# ***City of Albuquerque***

**RE: ALAMEDA BUSINESS PARK LOT 12 (C-16/D6R)**  
**(8501 Paseo Alameda NE) (Baker Office/Warehouse)**  
**ENGINEERS CERTIFICATION FOR CERTIFICATE OF OCCUPANCY**  
**ENGINEERS STAMP DATED 7/2/2001**  
**ENGINEERS CERTIFICATION DATED 8/6/2002**

**RE: ALAMEDA BUSINESS PARK LOT 12 (C-16/D6R)**  
**(8501 Paseo Alameda NE) (Baker Office/Warehouse)**  
**ENGINEERS CERTIFICATION FOR CERTIFICATE OF OCCUPANCY**  
**ENGINEERS STAMP DATED 7/2/2001**  
**ENGINEERS CERTIFICATION DATED 8/6/2002**

**RE: Grading and Drainage Plan submitted for ~~Baker Office~~  
~~Warehouse~~, (C-16/D006R), Lot 12, Alameda Bus. Park, Engineer stamp  
dated July 2, 2001.**

<b>PROJECT NAME</b> BAKER OFFICE-WAREHOUSE ALAMEDA BUSINESS PARK 8501 PASEO ALAMEDA NE ALBUQUERQUE, NM		<b>REVISIONS</b> NO. DATE	
<b>PROJECT NUMBER</b>		<b>DATE:</b> JUNE, 2001	
<b>DRAWING TITLE</b> GRADING & DRAINAGE PLAN		<b>C-1</b>

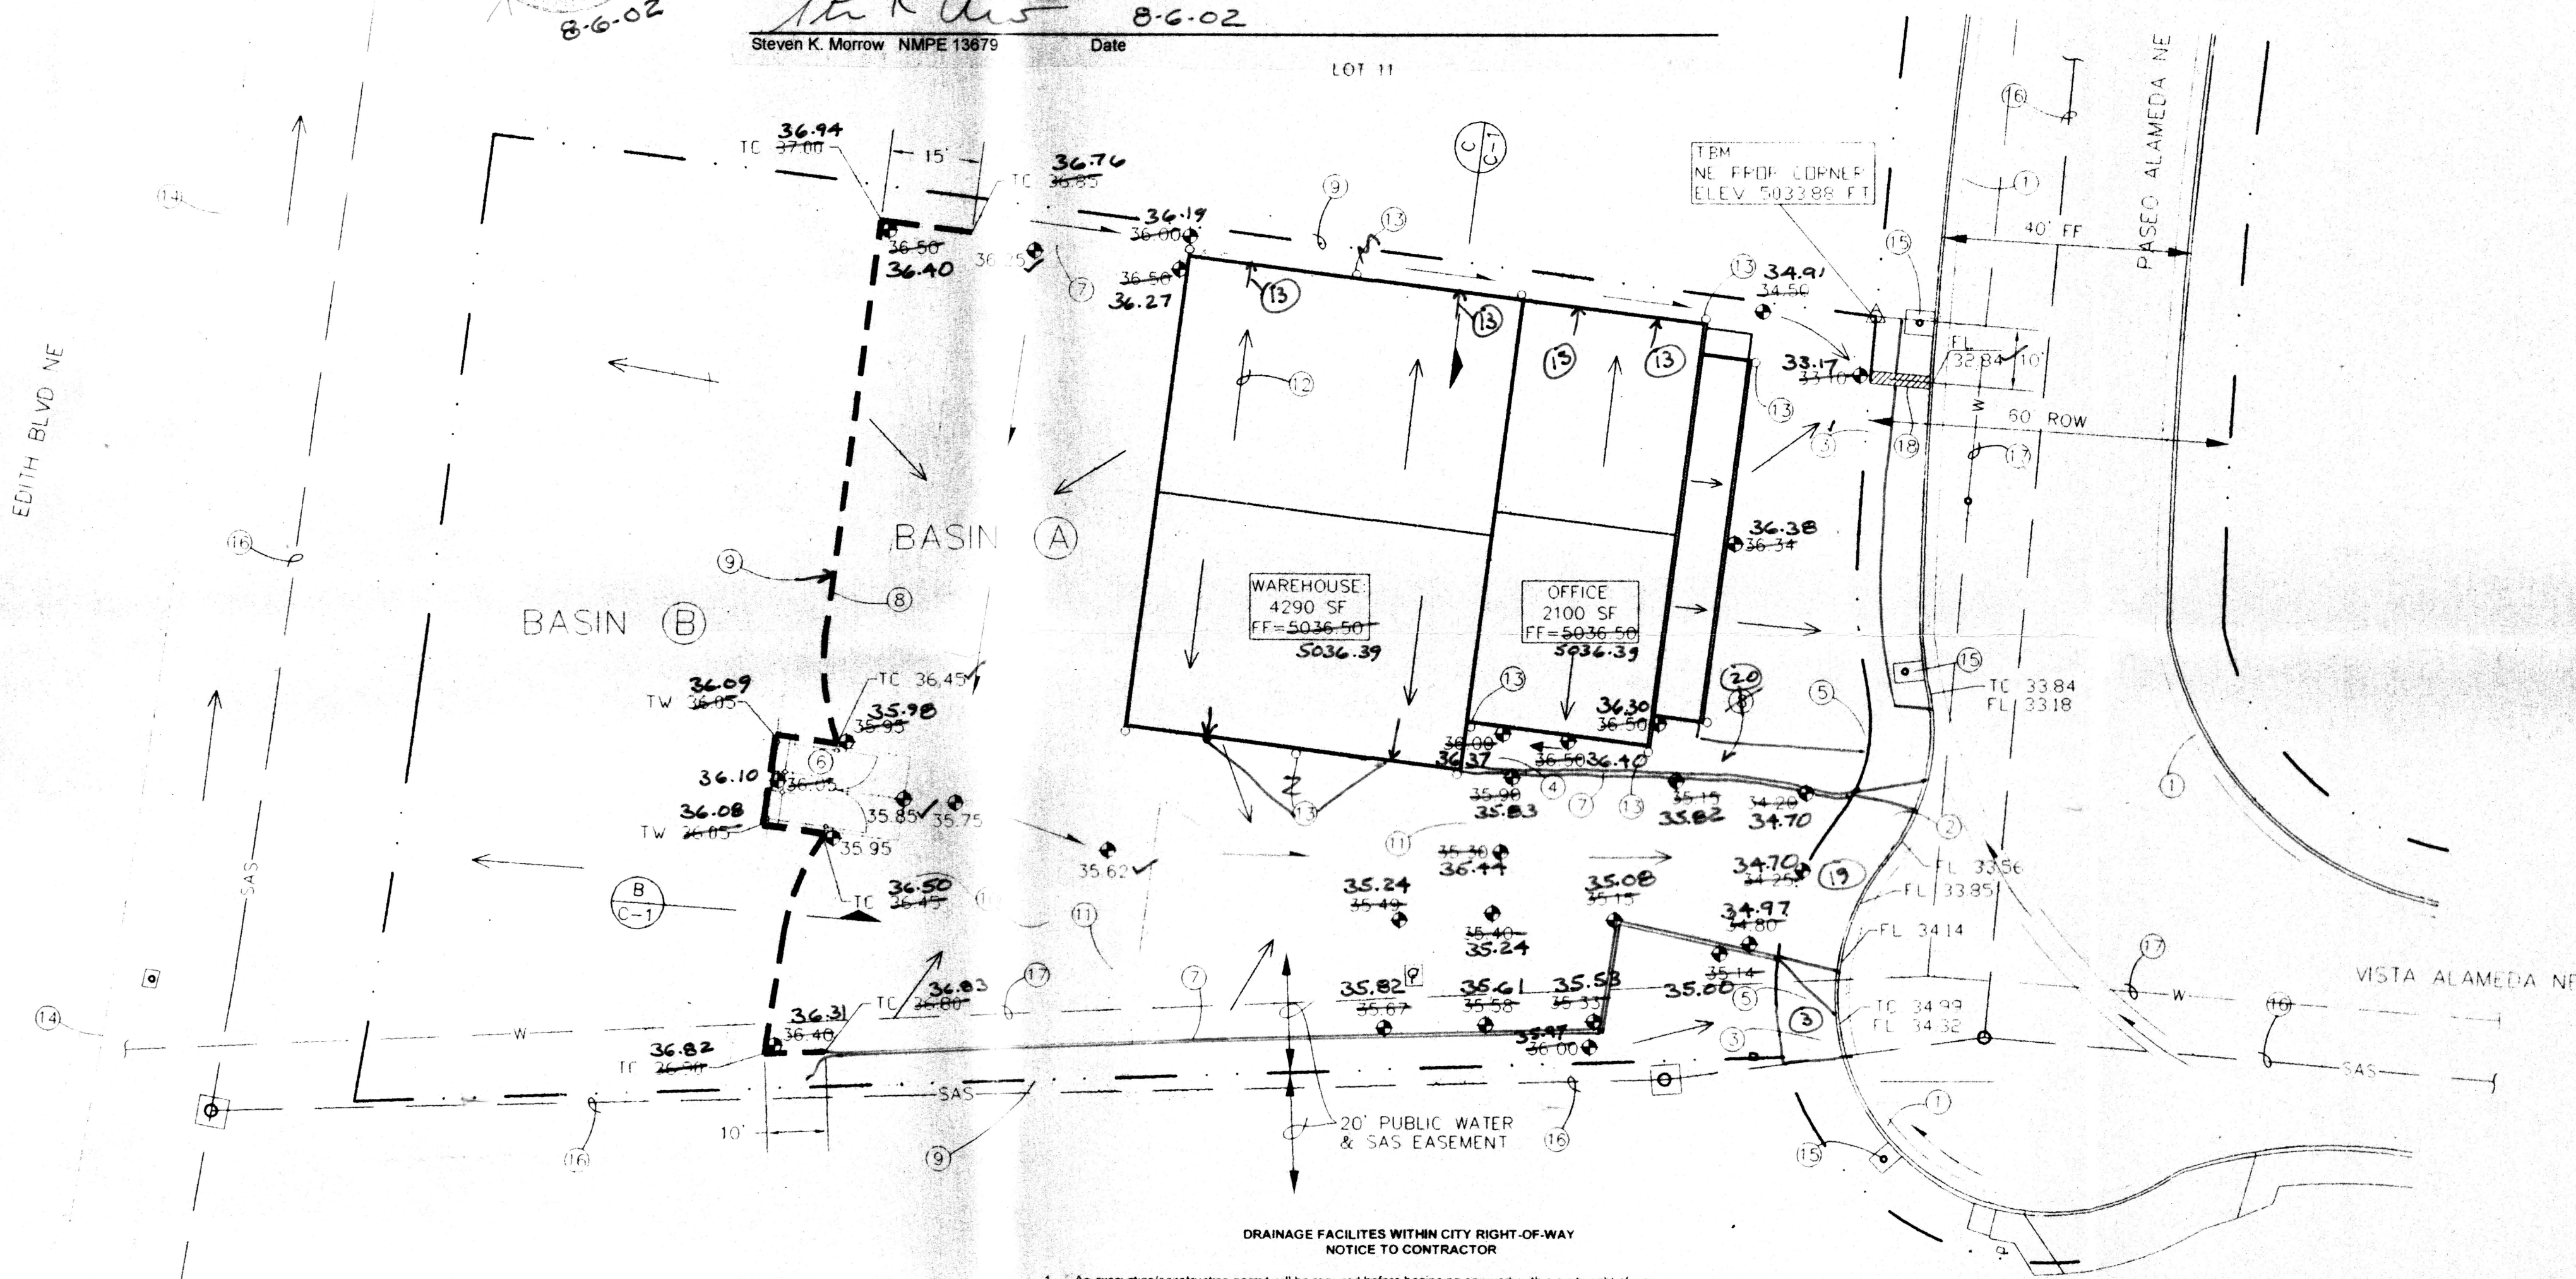
Please add a note on the final plan to seed and mulch the Basin B area with native grass mix, and attach the final plan to the building plan set.
